Our ref: 4081/Fixby/Letter 2

2021/091239/FU – Redevelopment of 410 & 412 Birkby Road, Huddersfield, HD2 2DN

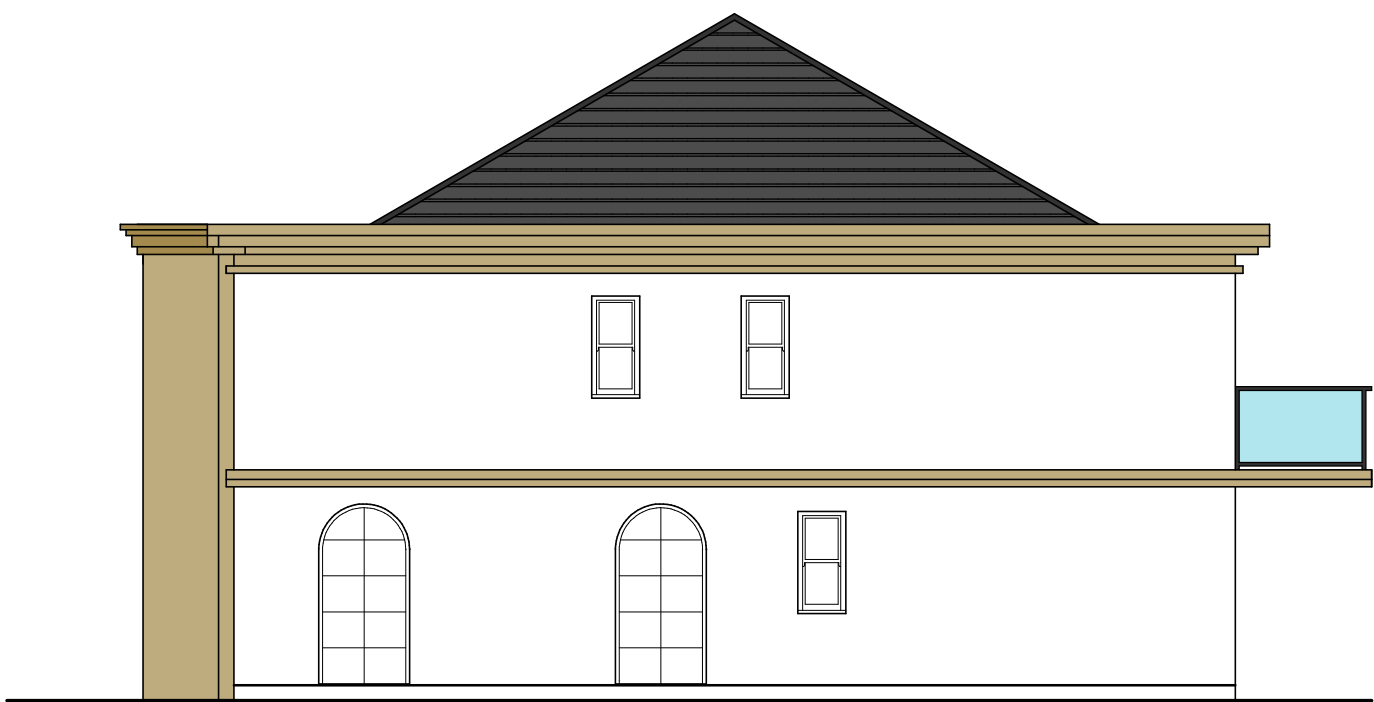
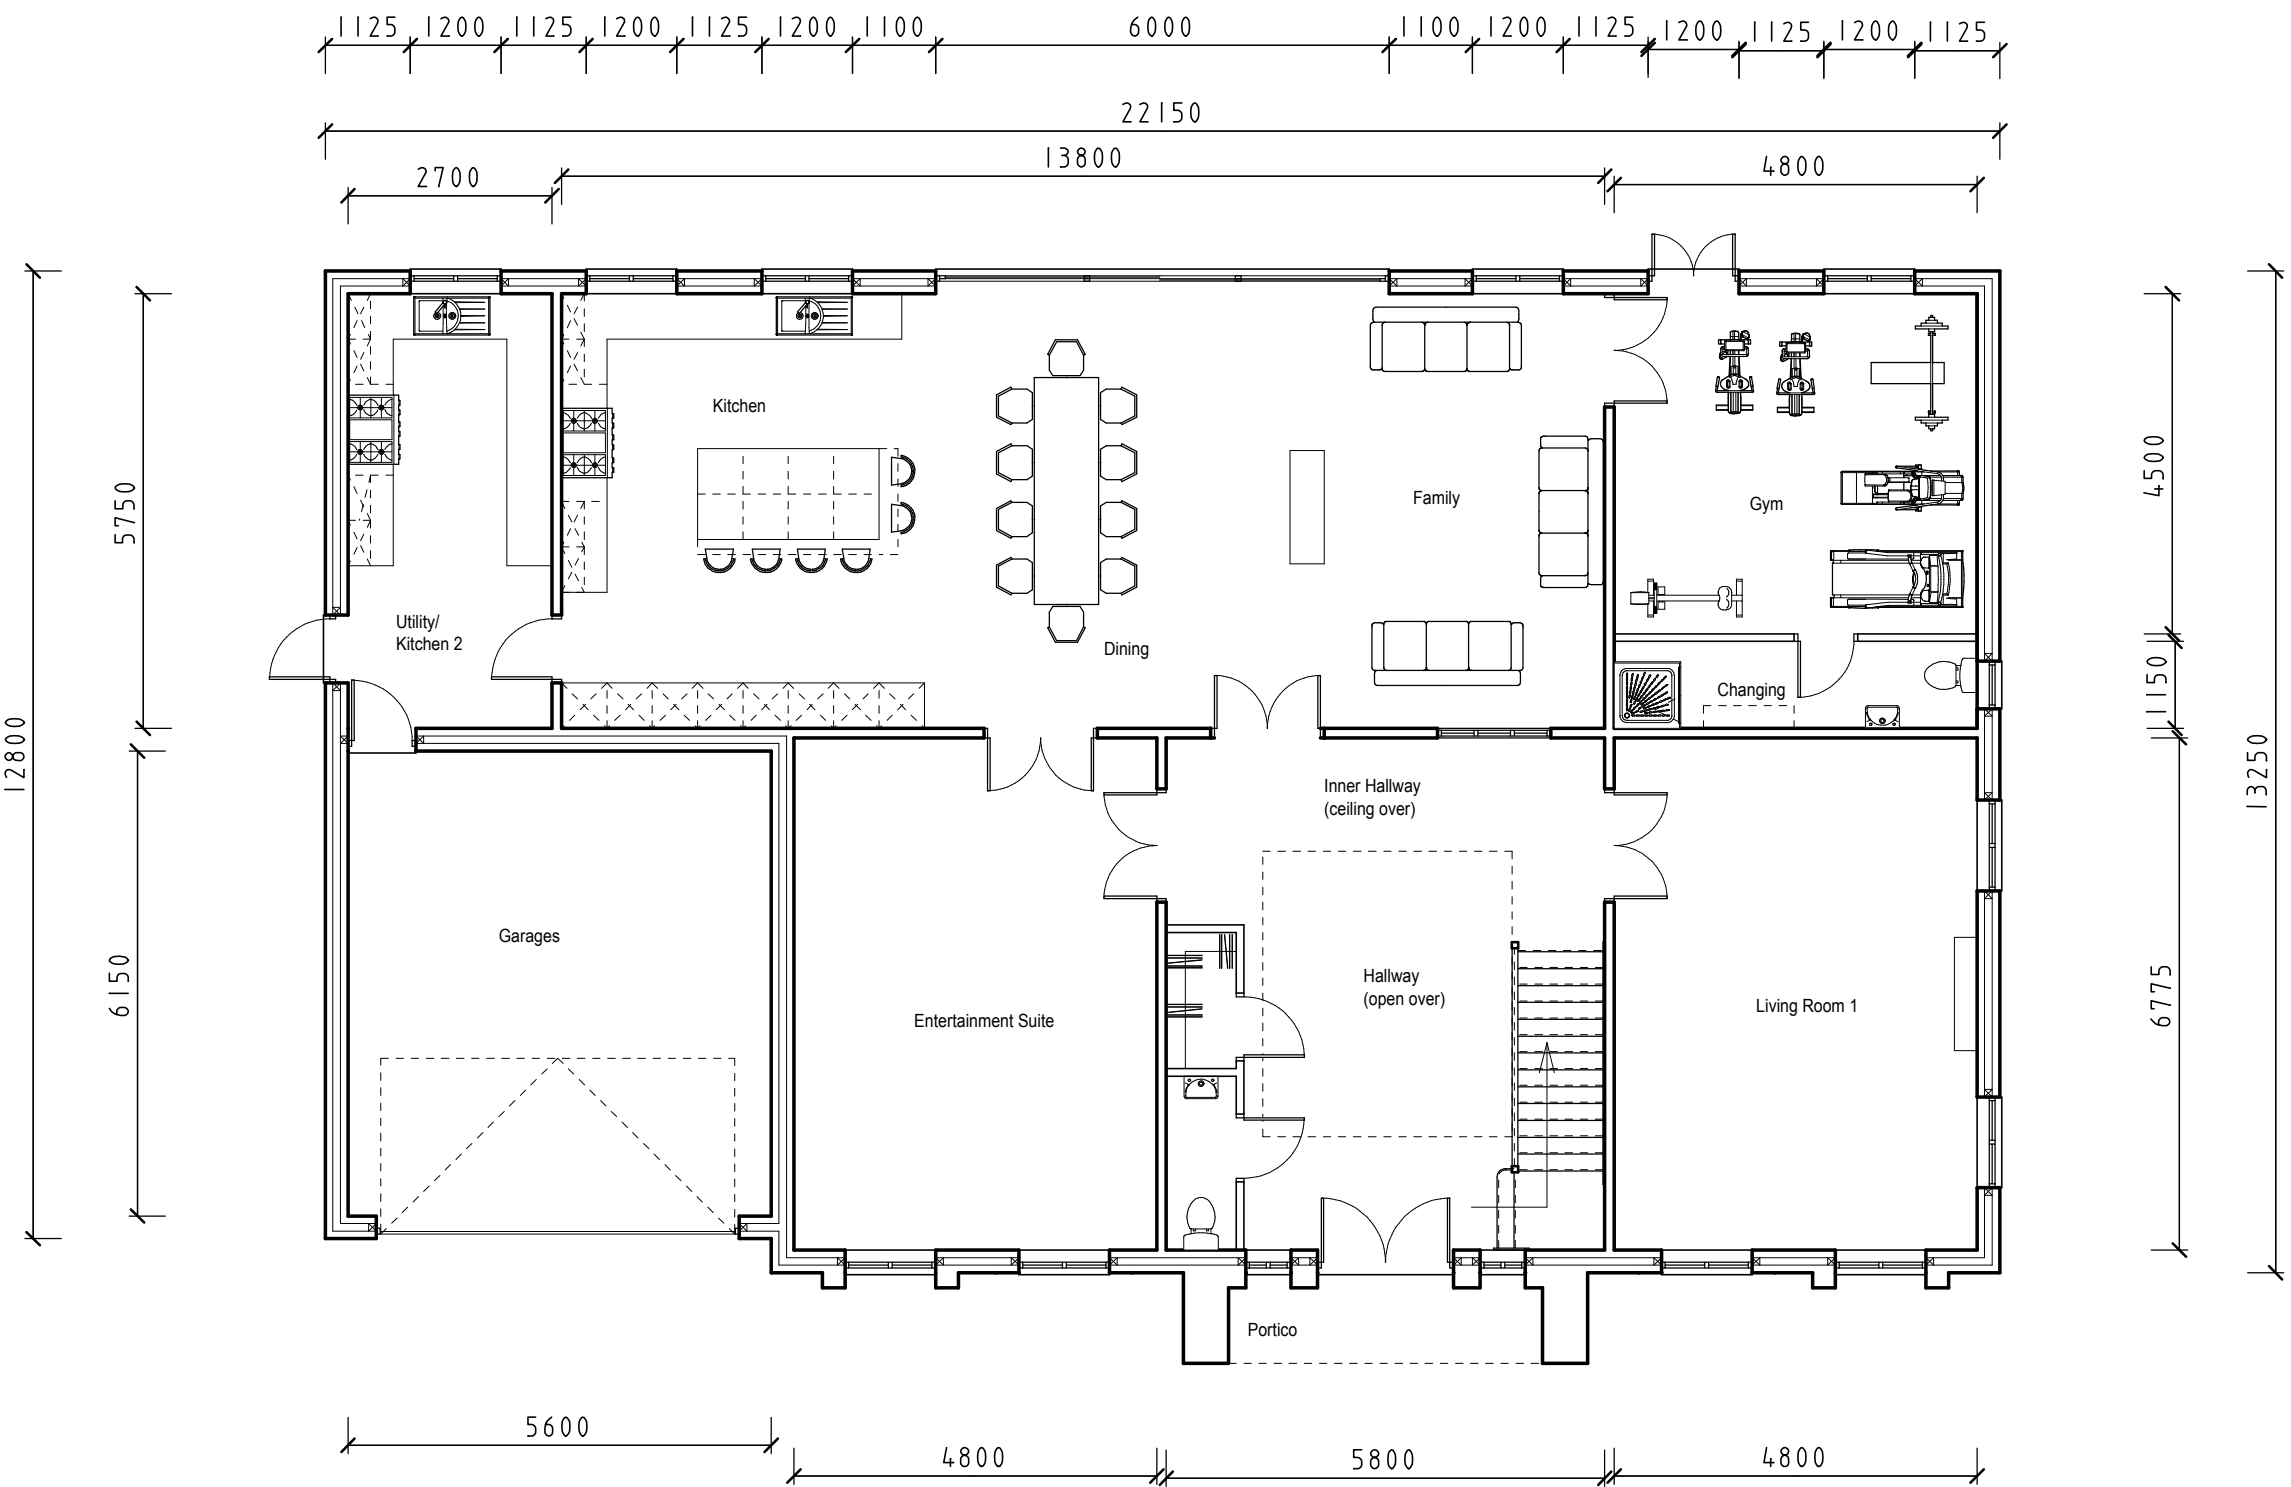
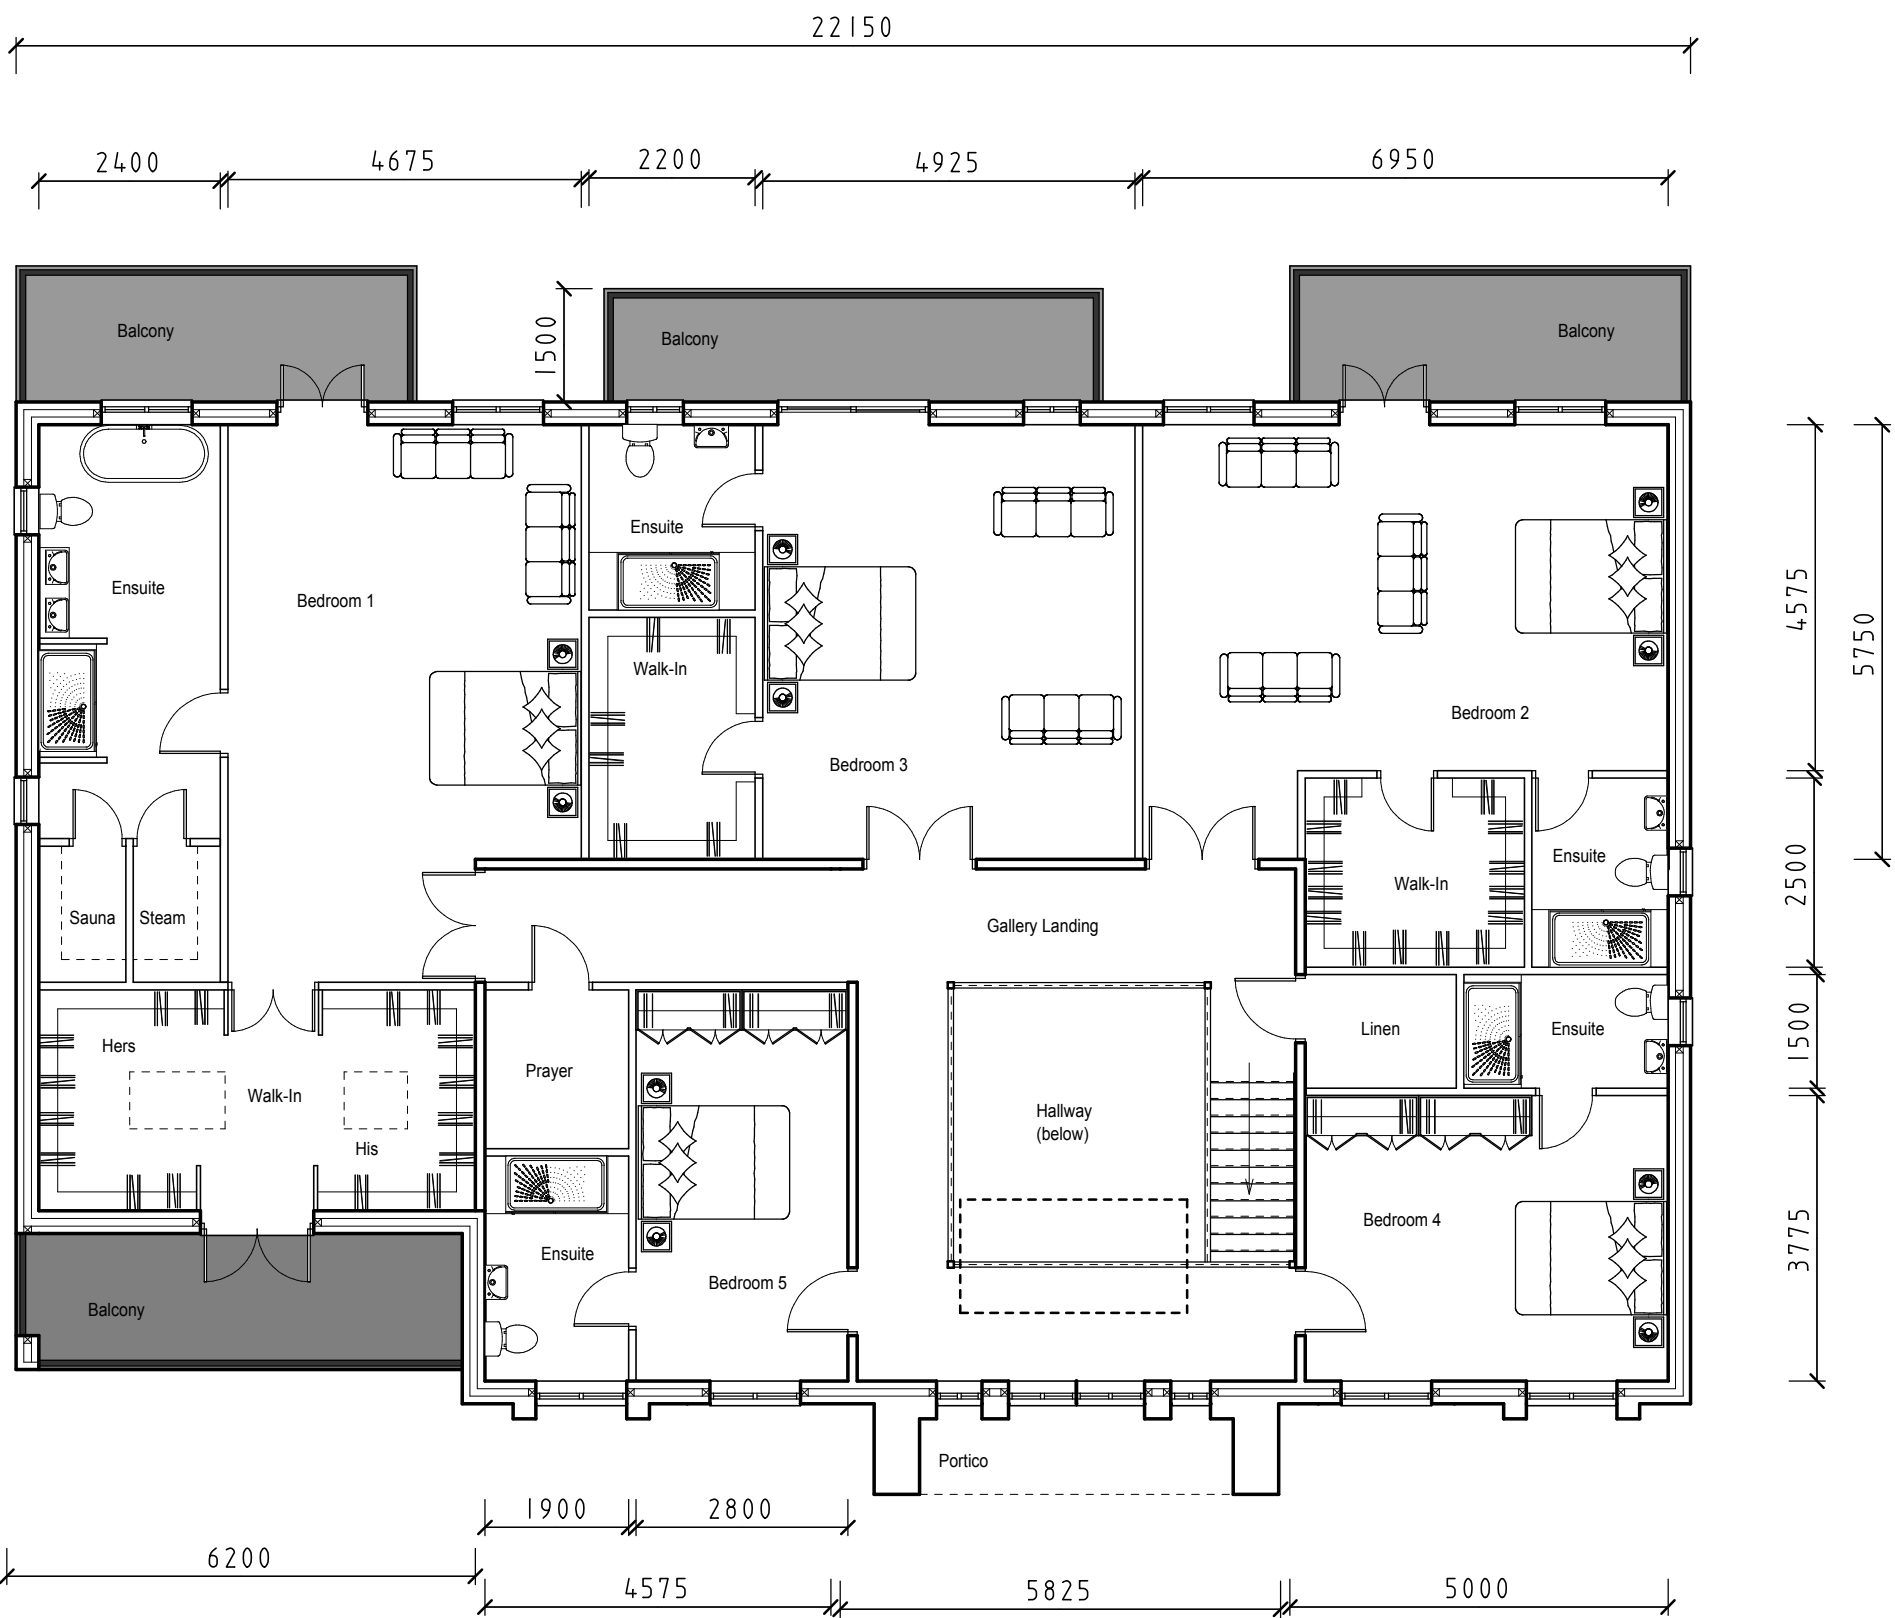
Whilst Dwelling B has been realigned the changes do not include the removal of the first floor extending balconies so that the issue of overlooking towards the property and garden at No 9 Valley Head remains. This will be a particular issue when the deciduous woodland is not in leaf – October to April. The balconies should be removed entirely or replaced with Juliet-type balconies.
